Level III Site Plan Application
Seaport Lofts: Submittal No. 4

SUMMARY OF RESPONSES TO NELL DONALDSON EMAIL DATED SEPTEMBER 10, 2013:

SUMMARY OF RESPONSES TO DAVID MARGOLIS - PINEO EMAIL RECEIVED SEPTEMBER 13, 2013
(18 COMMENTS IN MEMO DATED AUGUST 13, 2013):

**PROFILE: HANCOCK STREET**  
 STA. 3+11.7 TO STA. 6+75  
 SCALE: 1"=30' HORIZ.  
 1"=3' VERT.

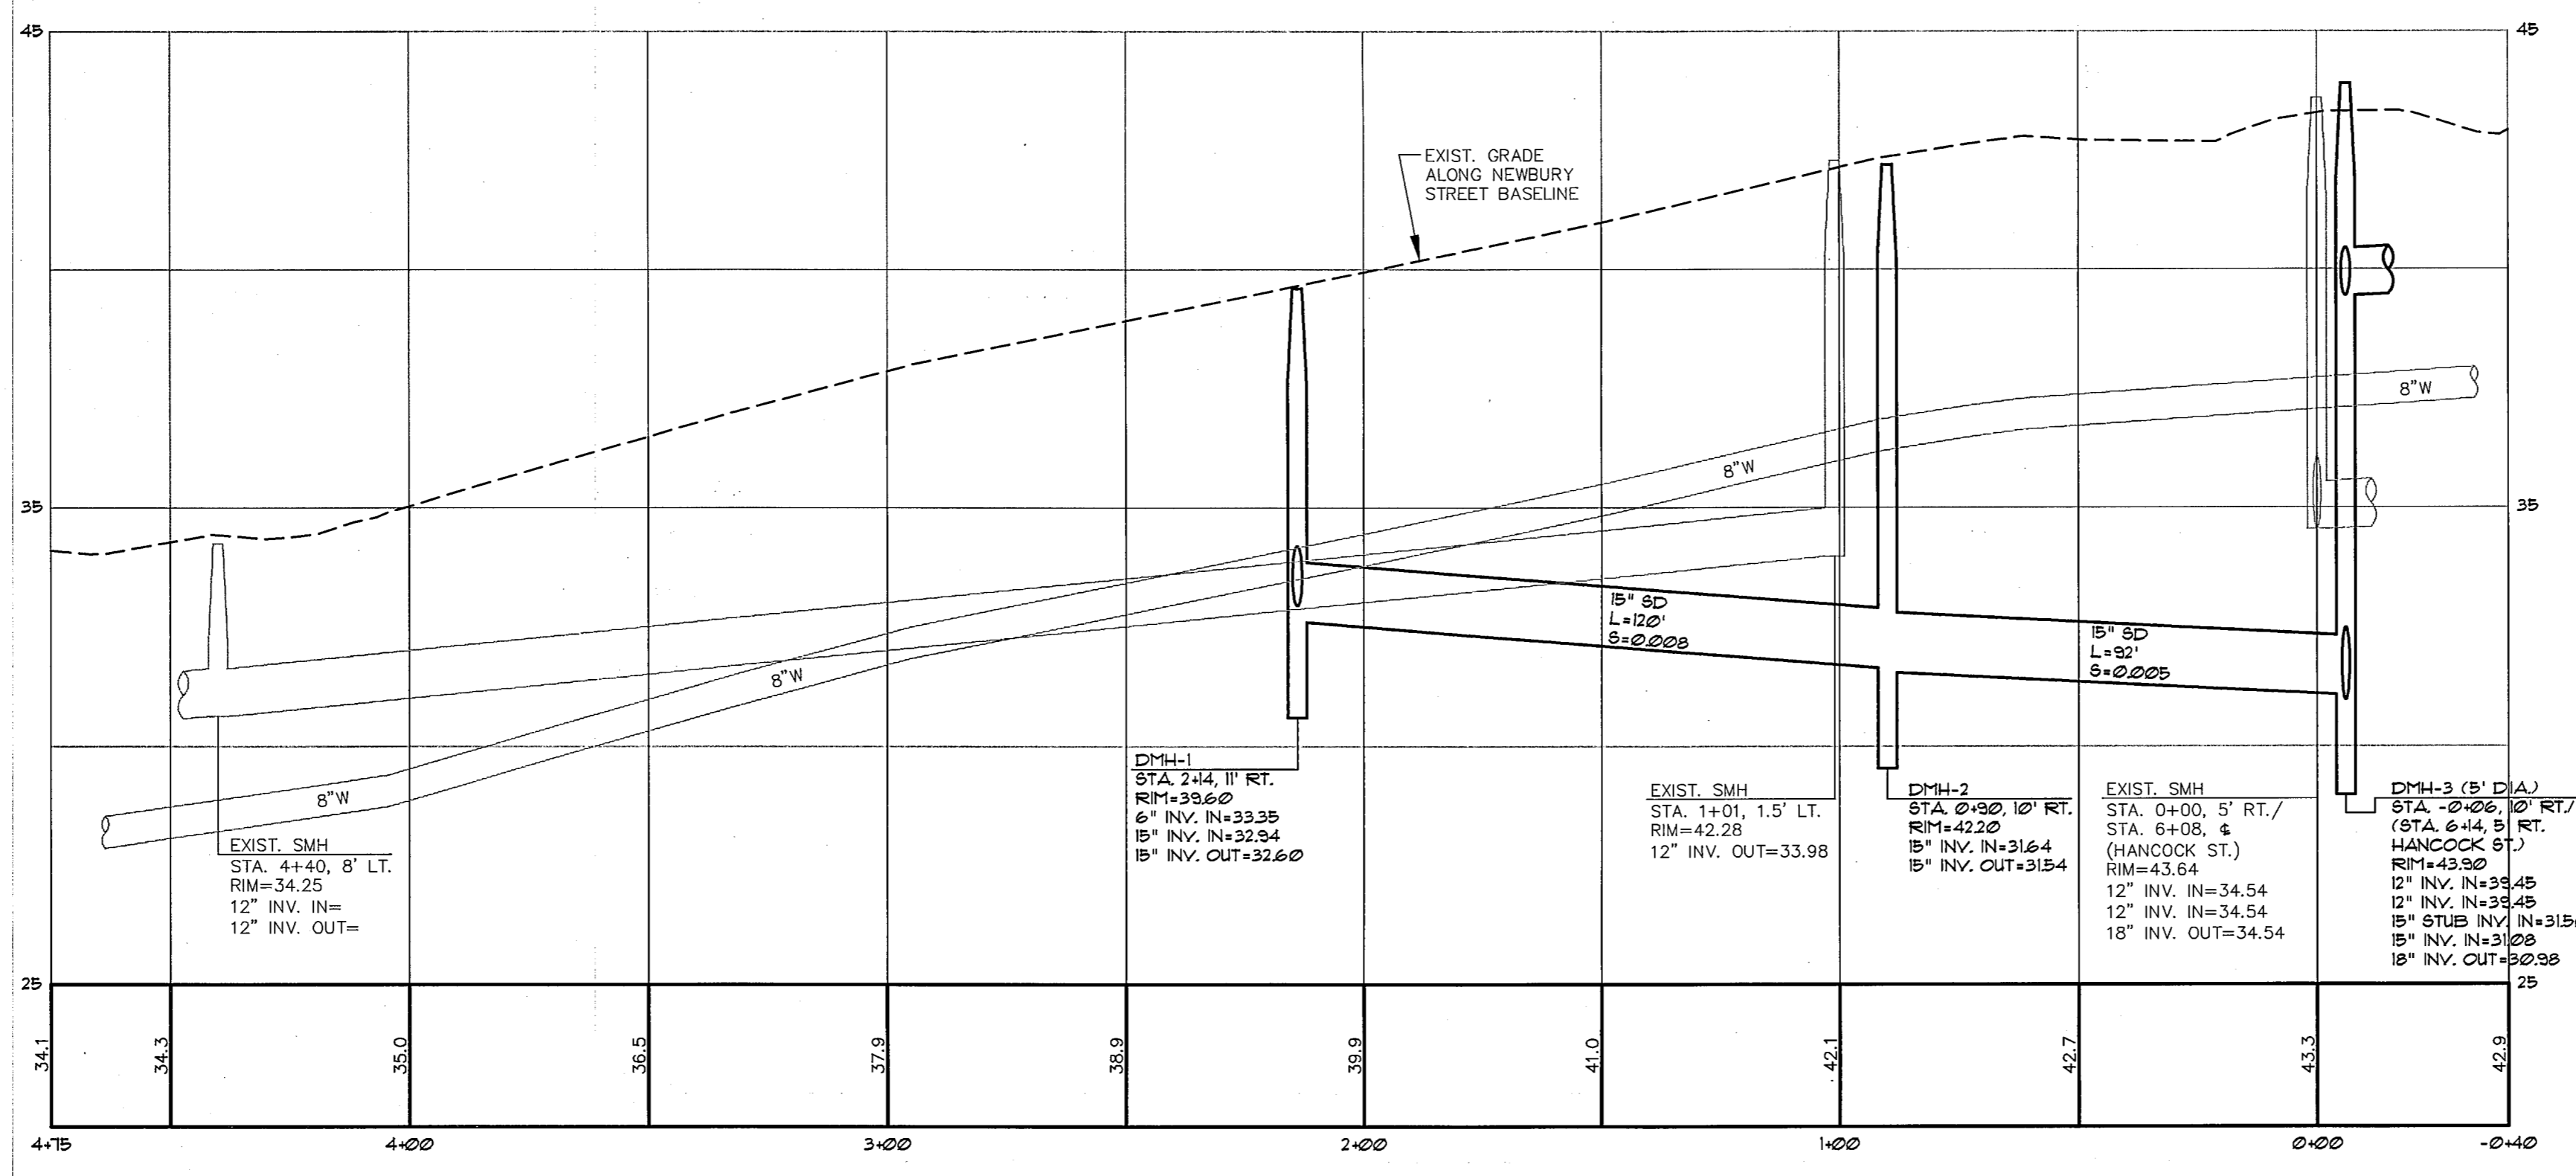
- #4 We have submitted plans of the proposed storm drain to the Portland Water District (See letter to PWD, Attachment U). The requested profile of the proposed storm drain is enclosed, see revised plan set.
